**COMMUNITY SERVICES DEPARTMENT**

March 11, 2022

**Subject: Homestead North at Sterling Ranch Phase I Preliminary Plan, Review #4 (SP-20-008)**

PRELIMINARY SITE PLAN

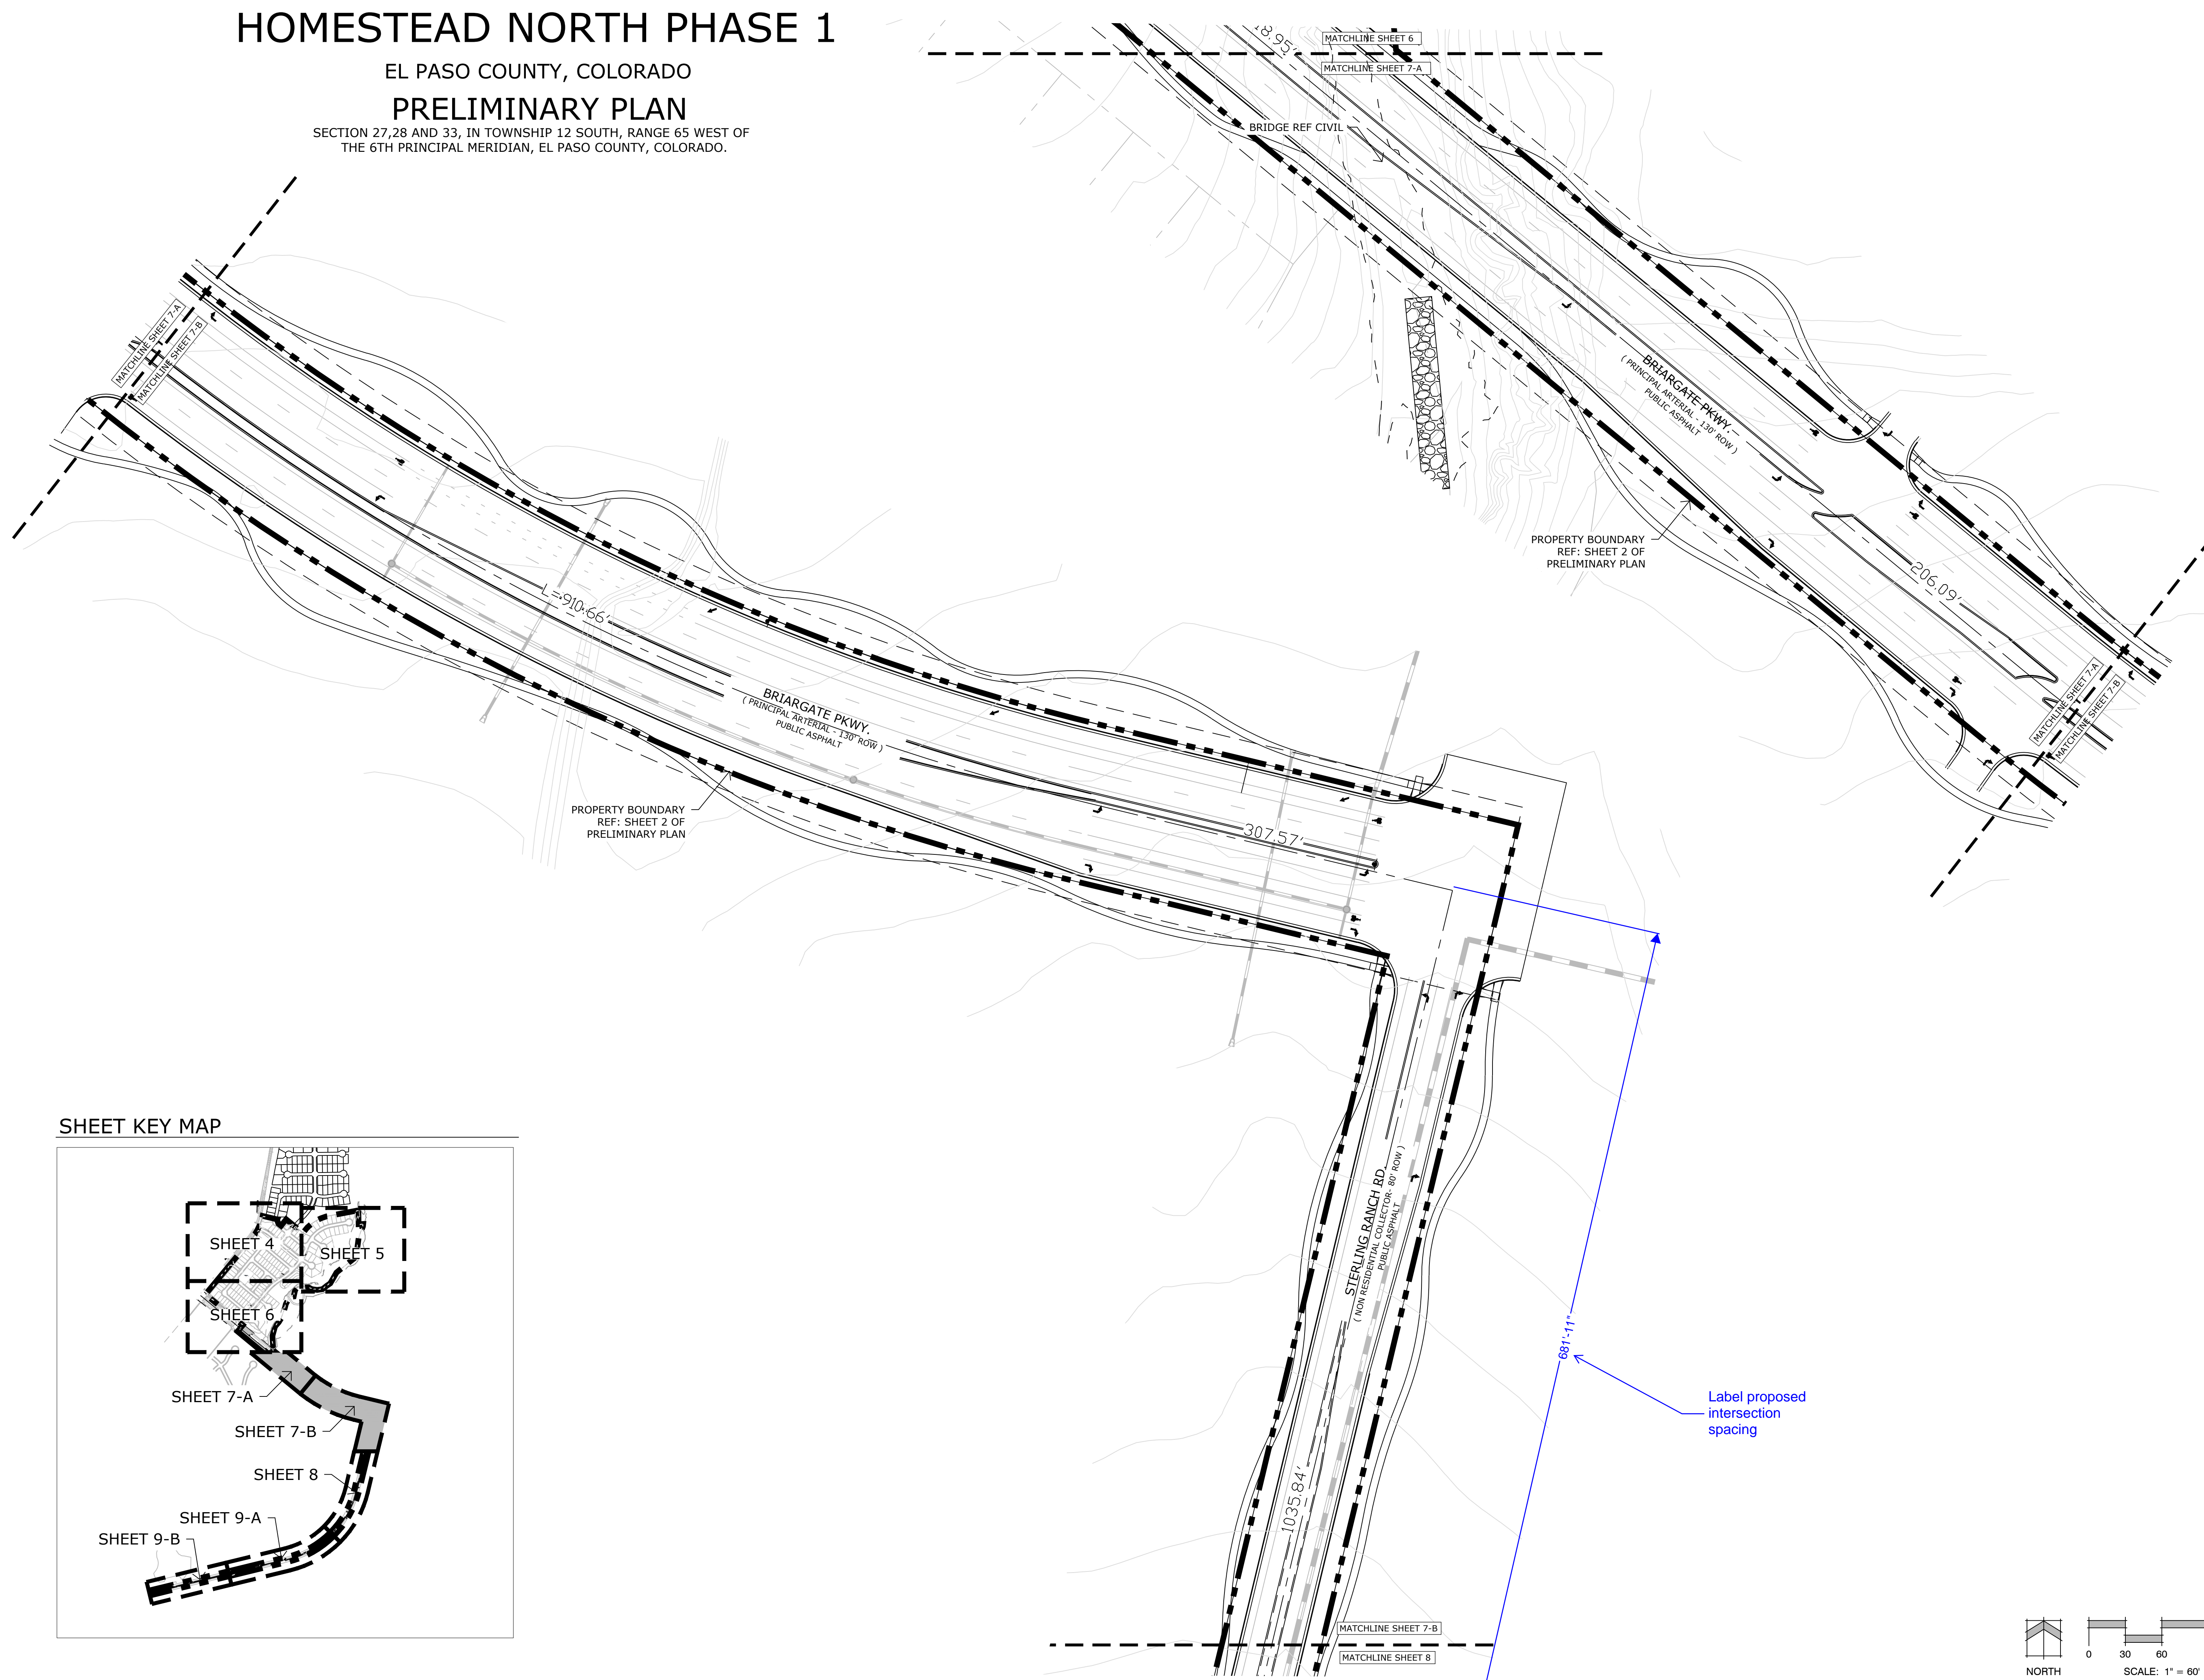
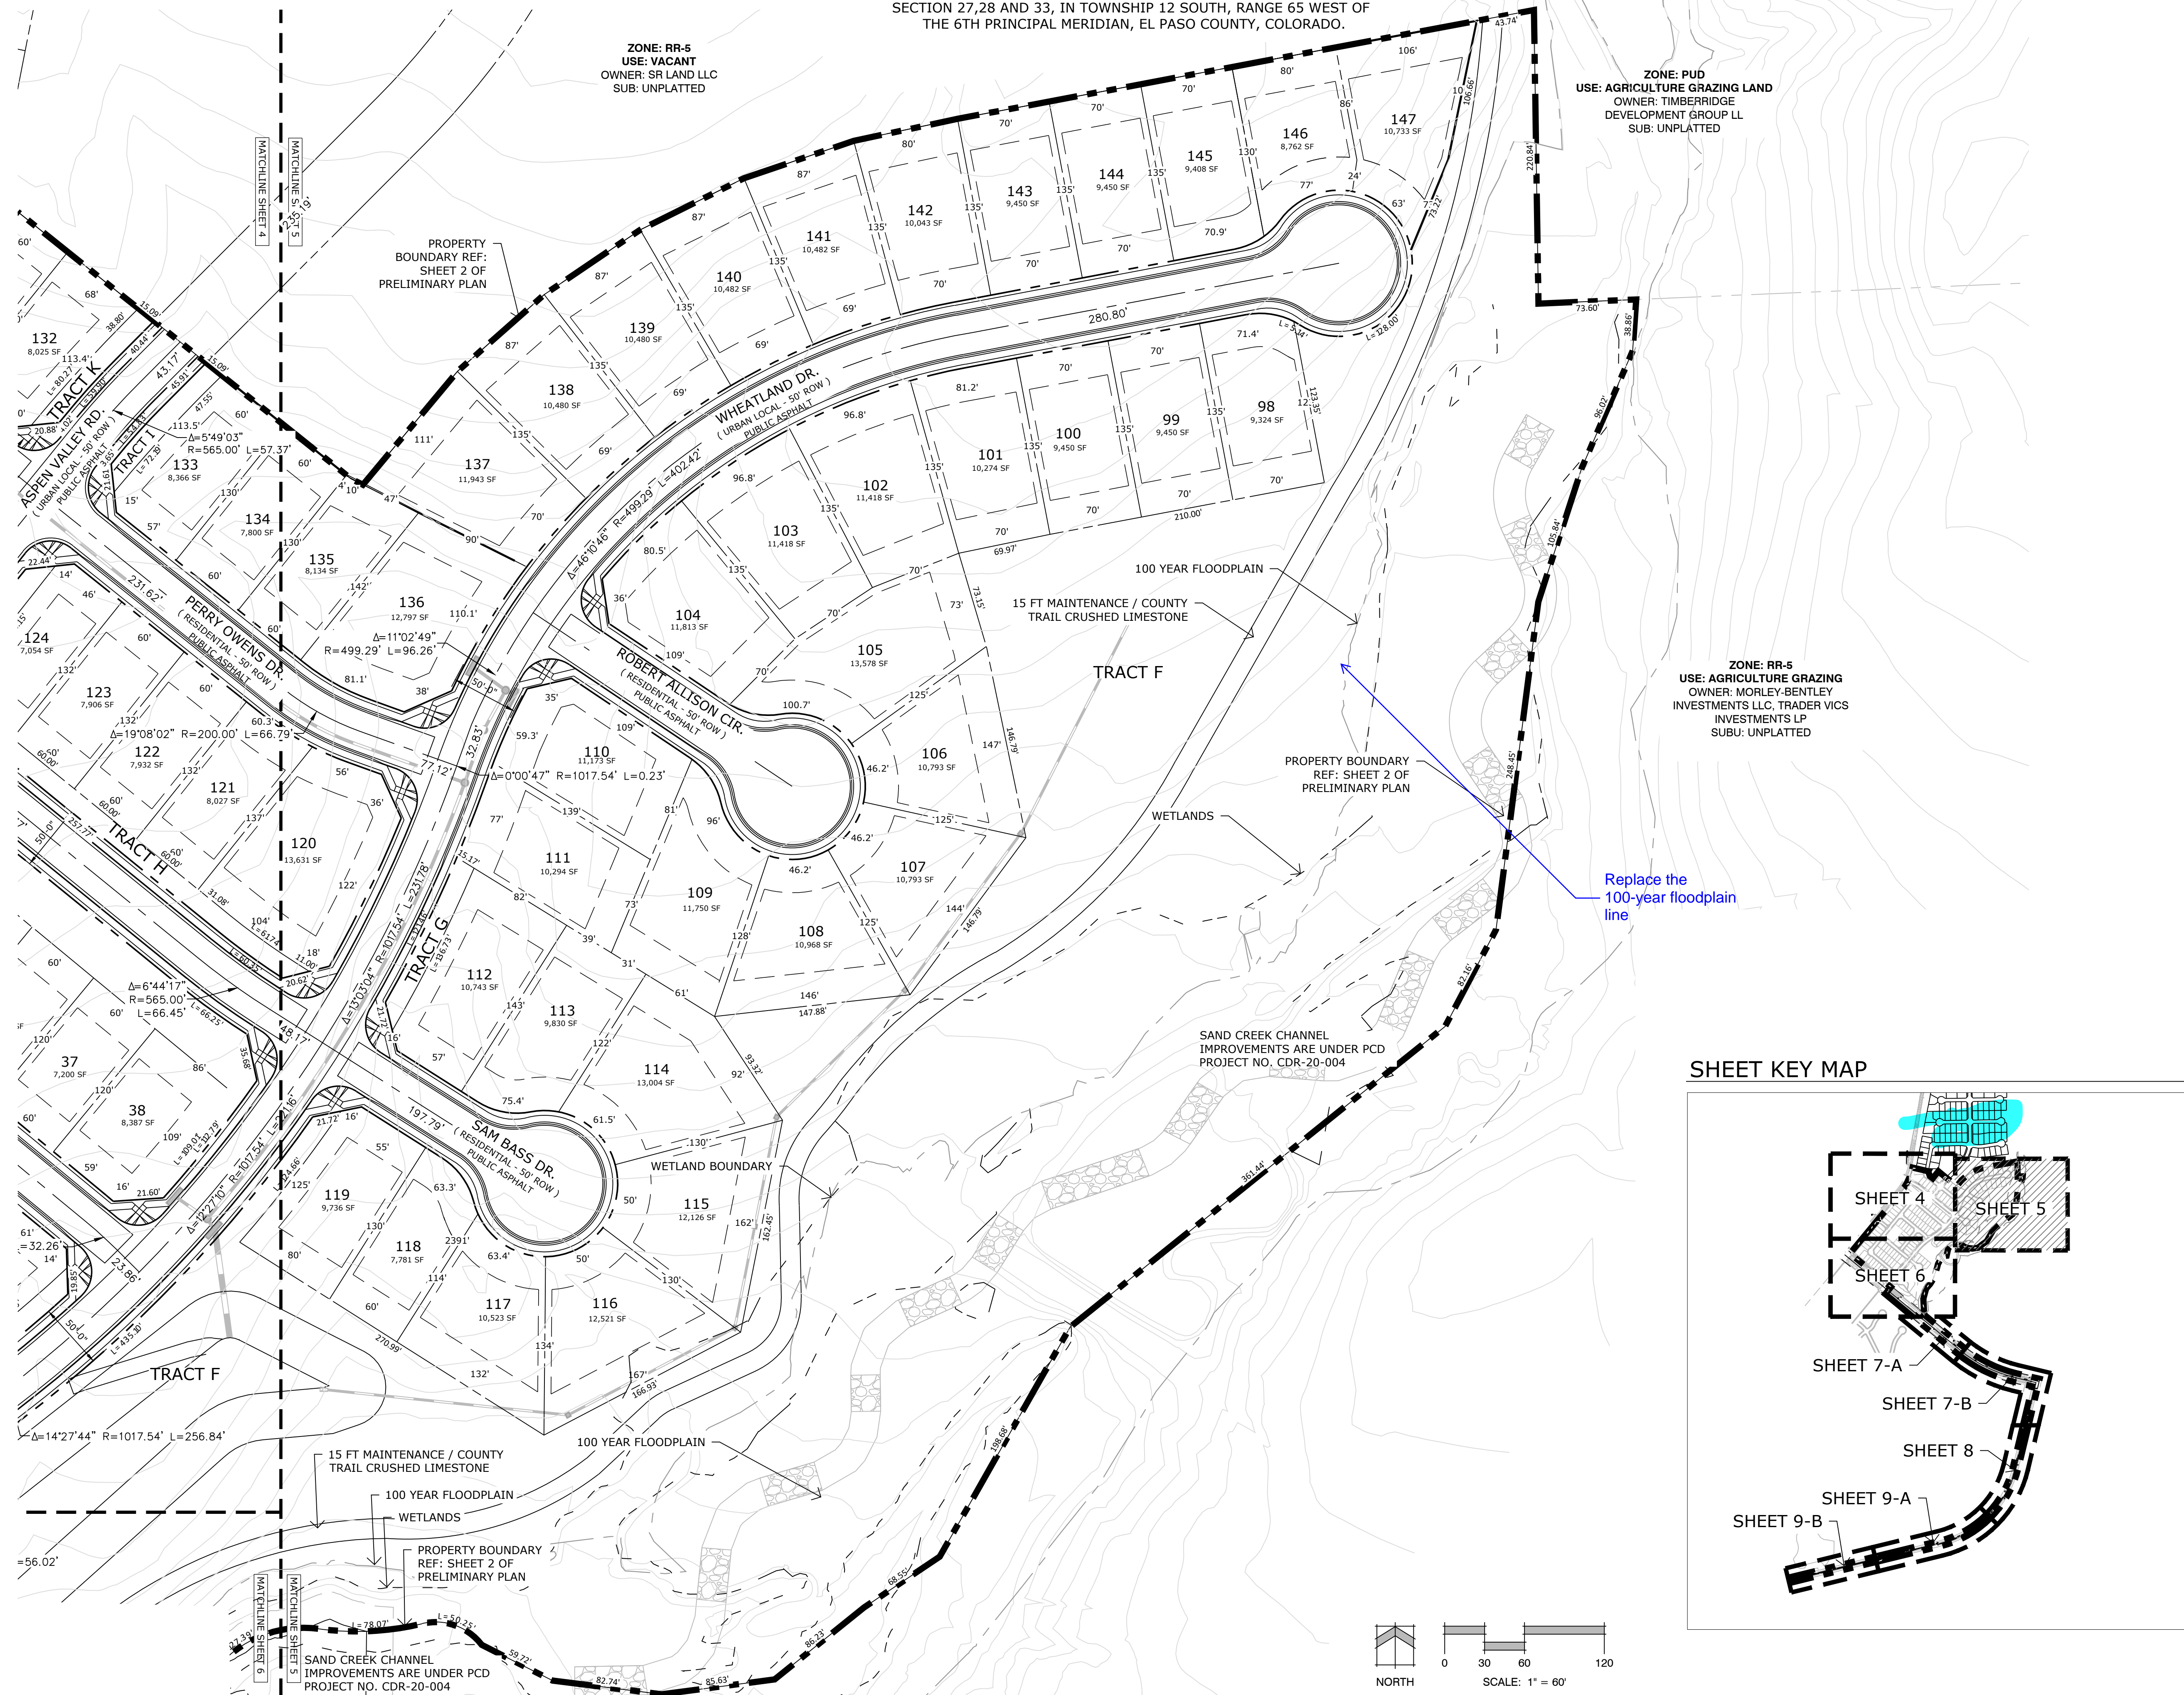
The Park Operations Division of the Community Services Department has reviewed the Homestead North at Sterling Ranch Phase I Preliminary Plan, Review #4, development application and has the following additional comments of behalf of El Paso County Parks. Since the previous comments were submitted (see below), El Paso County staff met with the applicant's representative and finalized the Sand Creek Primary Regional Trail along the western bank of Sand Creek within the bounds of the previous and currently submitted Sterling Ranch preliminary plans and final plats. The applicant has addressed staff's previous concerns, and the current Preliminary Plan submittal once again shows and labels the Sand Creek Regional Trail through Homestead North Phase I, and the aforementioned discussions confirmed the trail crossing of Briargate Parkway at Wheatland Drive, as the Sand Creek underpass cannot accommodate the trail alignment due to the tight confines of the Sand Creek channel realignment process.

*"EPC Parks staff continues to note the absence of the Sand Creek Regional Trail from the Preliminary Plan cover sheet and all additional sheets included with the Preliminary Plan. While a trail or road is shown in the Preliminary Plans, it is labeled as a "15' Maintenance Trail" and does not continue south of Briargate Parkway. The General Notes section does mention that trails labeled as "County Regional Trail" will be maintained by El Paso County, but none exist on this iteration of the Preliminary Plan.*

*“Staff questions the removal of the Sand Creek Regional Trail alignment and labeling from the Preliminary Plan, particularly on the cover page and Site Plans. The included utility and grading plans do show what appears to be the Sand Creek Regional Trail, but there are no labels indicating it as so. As noted in the following comments and recommendations, as endorsed by the Park Advisory Board on January 13, 2021, EPC Parks is requesting a 25’ trail easement for the construction and maintenance of the Sand Creek Regional Trail. Staff also requests clarification as to the number of neighborhood parks proposed for Homestead North. The current Letter of Intent mentions one 0.87-acre park located in Tract B, but also indicates a park in Tract F. The location of the Tract F park is not indicated in the Preliminary Plan. Furthermore, staff acknowledges the increase in Preliminary Plan acreage from 60.6 acres to 77.7 acres due to the inclusion of the eastern and southern extensions of Briargate Parkway and Sterling Ranch Road, respectively.”*

*The proposed Sand Creek Regional Trail is depicted in the Preliminary Plan, and labeled as “10’ County Gravel Trail,” although when constructed, the trail will follow EPC Parks Tier I Trail standards with an 8’ wide crusher fine trail surface with 2’ natural shoulders. The Preliminary Plan also shows concrete sidewalks/trails located adjacent Vollmer Road and the future Briargate Parkway extension. These non-County trails will allow for direct off-street connectivity to the Sand Creek Regional Trail for the residents and visitors of Sterling Ranch.*

*Due to the location of the Sand Creek Primary Regional Trail within the Homestead North at Sterling Ranch Phase I development, El Paso County Parks staff recommends that the applicant designate, provide, and dedicate to El Paso County a 25-foot trail easement that allows for the construction, maintenance, and public access of the regional trail. Furthermore, staff recommends fees in lieu of land dedication for regional and urban park purposes.*

*The Park Advisory Board recommends that the Planning Commission and the Board of County Commissioners include the following conditions when considering and/or approving the Homestead North at Sterling Ranch Phase I Preliminary Plan: (1) designate and provide to El Paso County a 25-foot trail easement through Homestead North at Sterling Ranch, within Tract F, that allows for construction, maintenance, and public access of the Sand Creek Primary Regional Trail, and dedicate the easement to El Paso County prior to the recording of the forthcoming final plat(s); 2) include descriptions, drawings, and locations of the two neighborhood parks in the Letter of Intent and Preliminary Plans, respectively; 3) fees in lieu of land dedication for regional park purposes in the amount of \$68,649 and urban park fees in the amount of \$43,365 will be required upon recording of the forthcoming final plat(s). A Park Lands Agreement may be an acceptable alternative to urban park fees, provided the agreement is approved by the County and executed prior to recording the forthcoming final plat(s)."*
